# CITY OF ALBUQUERQUE

January 11, 2022

**Re: Pima Medical Institute New Class Room Building**  
**4400 Culter Ave NE**  
**Traffic Circulation Layout**  
Architect's Stamp 01-05-2022 (H17-D054B)

TCL001

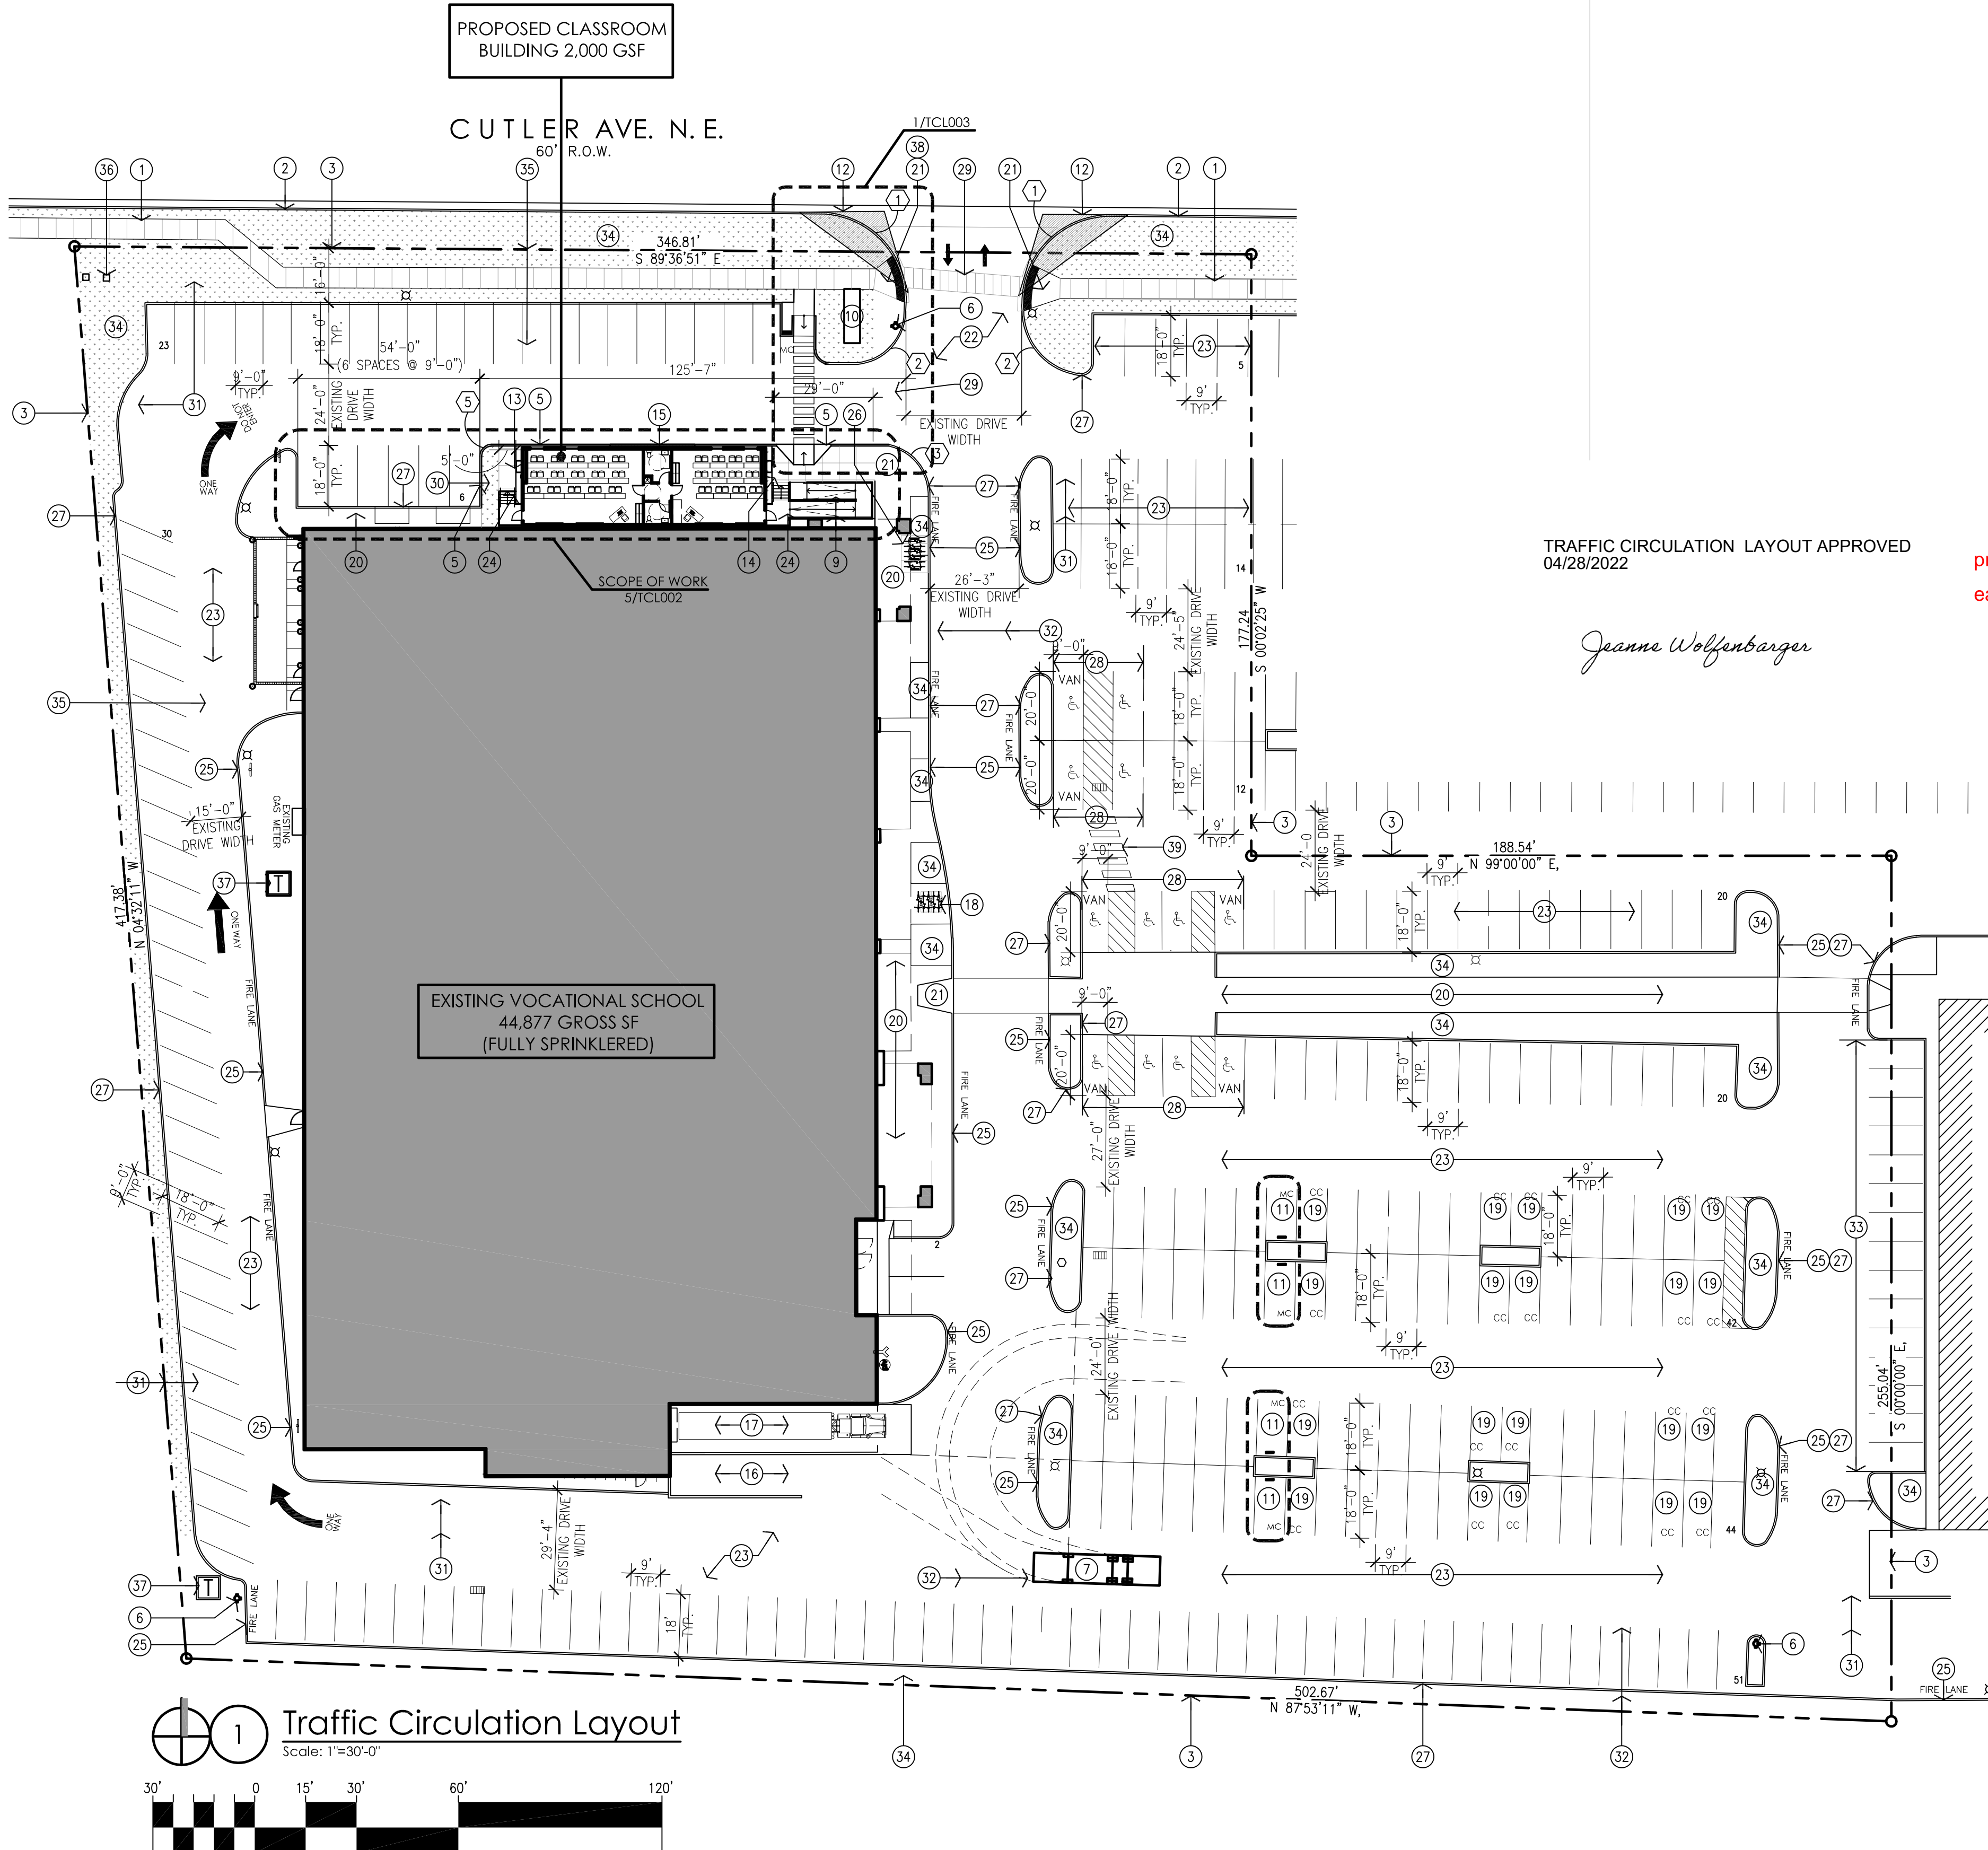
- Verify both existing ramp, at entrance, are update/current ADA .
- The western leg of entrance ramp **might** in conflict with the existing sidewalk connection onto site. Please verify the ramp is not in safety/ADA conflict.
- **Keyed Note 38:** Calls out truncated domes but pattern concrete existing on ramp legs. Will proposed domes complicated the existing patters? Verify
- You will need a Sidewalk Easement for existing sidewalk located outside of public ROW. See attachment for the forms.

SHEET
TCL003

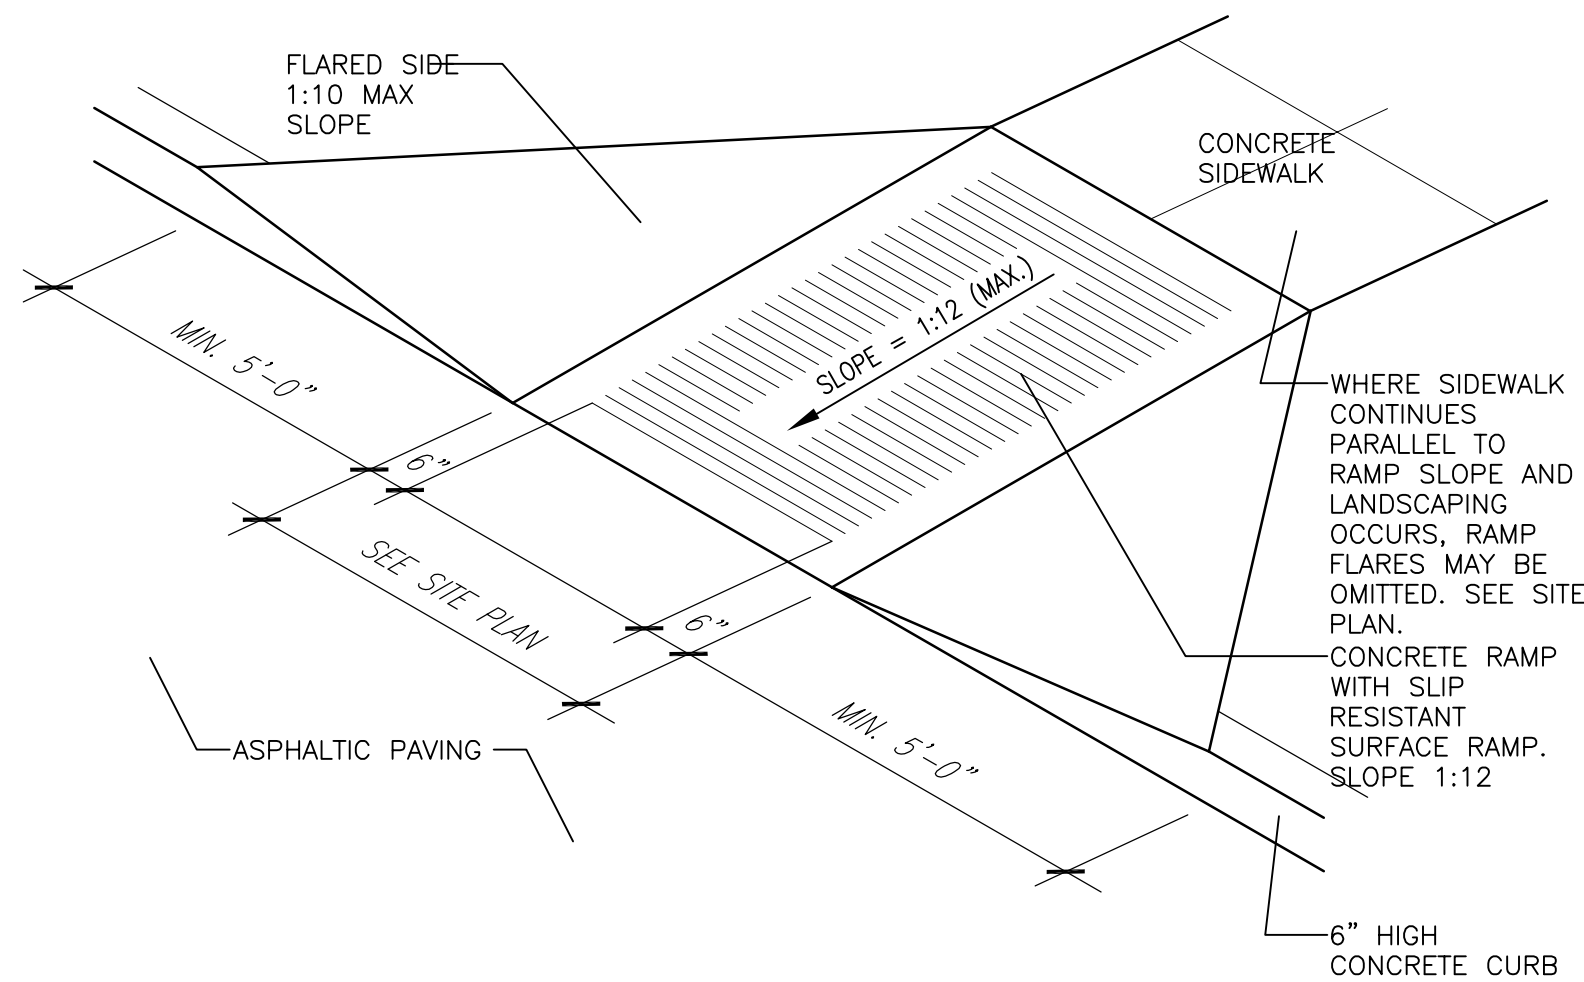
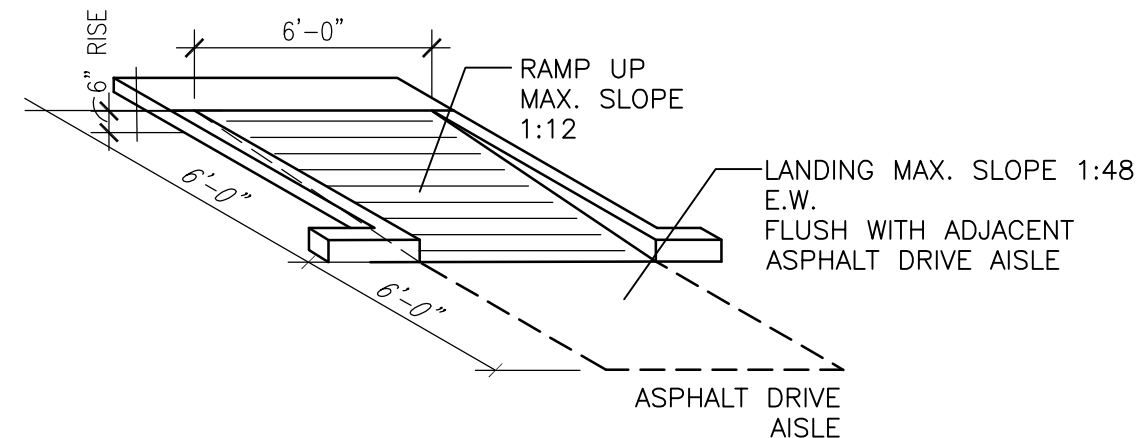
2. **Keyed Note 9:** This note calls out ramp but no detail has been provided. A detail will need to be provide on all segments of proposed and to include: top/bottom handrail Extension, each segmen with landing (5'x'5 landings @2%), ramp landings/runs (12:1max) per ADA Standards for Accessible Design Guide.
